From: Mark Iveson [REDACTED]
Sent: 09 June 2017 [REDACTED]
To: Anita Gardner
Subject: EP/63/16/PL RE: Bradbury Hotel Site, East Preston - Email 1 of 2

From: Anita Gardner [REDACTED]
Sent: 07 June 2017 12:52
To: Richard Skelley <[REDACTED]>
Cc: Tracey Headley-Smith <[REDACTED]> Delwyn Jones <[REDACTED]>
Subject: FW: EP/63/16/PL RE: Bradbury Hotel Site, East Preston

Council's Drainage Engineer Paul Cann on 01903 737819. His most recent comments were recorded in the refusal reason on EP/10/17/DOC and are set out below for information.

EXPLORATORY HOLE LOCATION PLAN

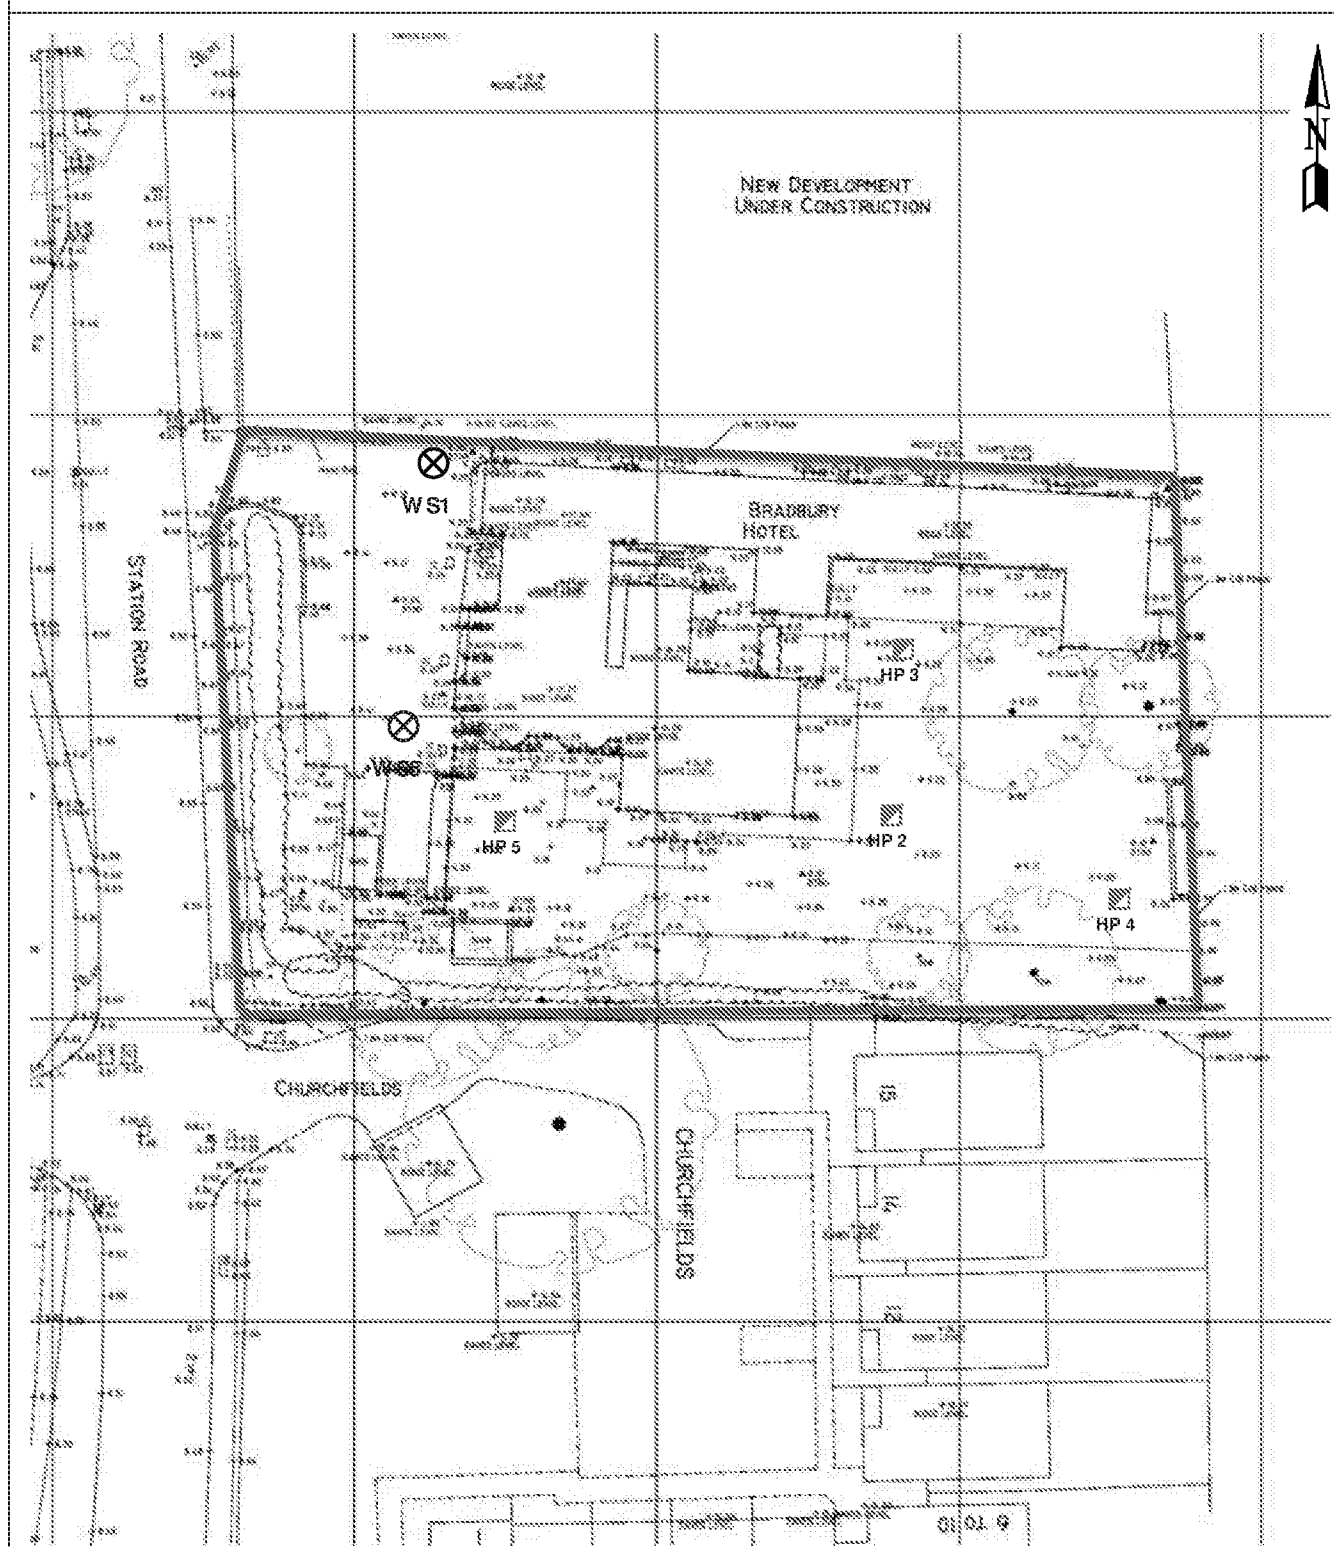
1. No winter groundwater data has been provided. This is critical to the design.
2. Provide the date of when the percolation tests were undertaken, together with a plan showing their locations. Confirm at what depth (ie. water fill level below ground level) each test commenced.

2. Provide the date of when the percolation tests were undertaken, together with a plan showing their locations. Confirm at what depth (ie. water fill level below ground level) each test commenced.
Locations of tests are attached -- See Test locations.pdf. See Perculation Test notes.pdf for the additional information required.

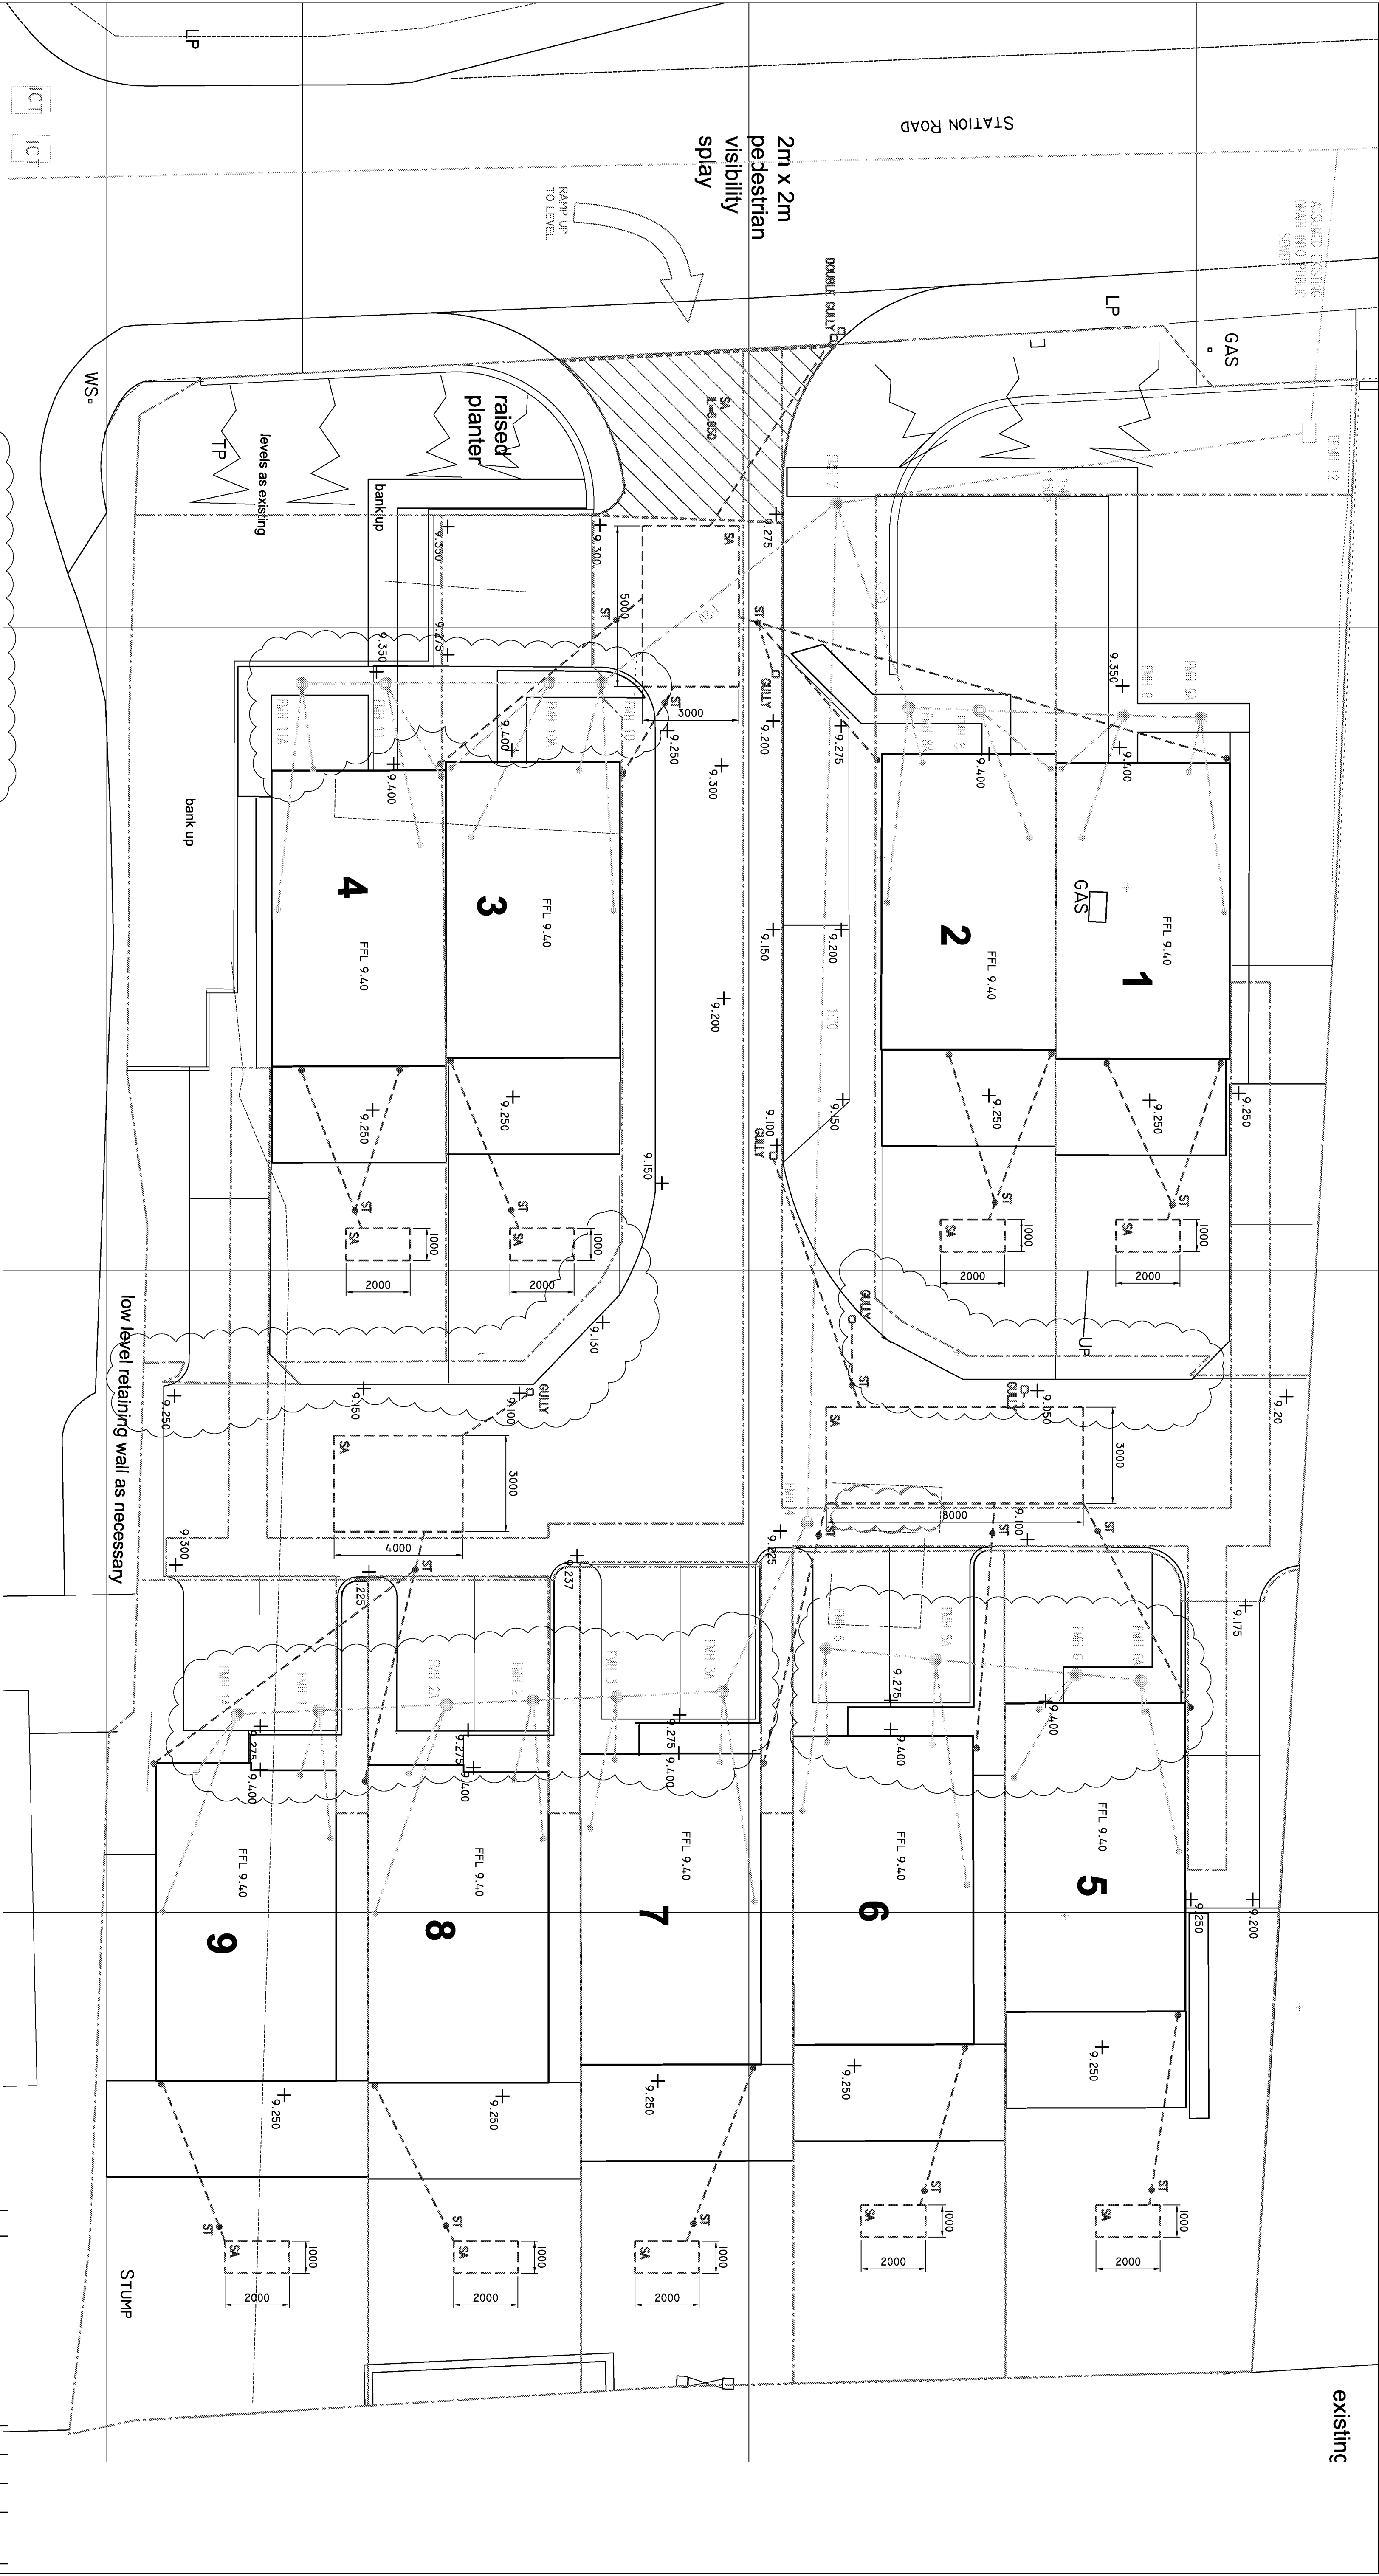
6. Additional silt interception is required in the form of catchpit manholes. These are required on all entries to soakaways and also allow a means to clean the upstream pipework.

7. Full constructions details (ie. drawing) of each soakaway structure, gullies and catchpits, etc., are required.
8. Specify pipe gradients/invert levels on all pipes connecting to soakaways.

9. Specify gully outlet invert levels and finished levels for the grated cover. This item may be affected by item 5 of this email.
10. The operation and maintenance manual needs to comply with 'The Suds Manual C753' chapter 32. I also suggest that specific structure type pages in the manual are observed ie. P.467-468 for geocellular tanks.'

6. Additional silt interception is required in the form of catchpit manholes. These are required on all entries to soakaways and also allow a means to clean the upstream pipework.
See attached drainage layout rev C01. Silt trap manholes provided.

7. Full constructions details (ie. drawing) of each soakaway structure, gullies and catchpits, etc., are required.
See attached details drawing.
8. Specify pipe gradients/invert levels on all pipes connecting to soakaways.
See attached drainage layout rev C01

9. Specify gully outlet invert levels and finished levels for the grated cover. This item may be affected by item 5 of this email.
See attached drainage layout rev C01
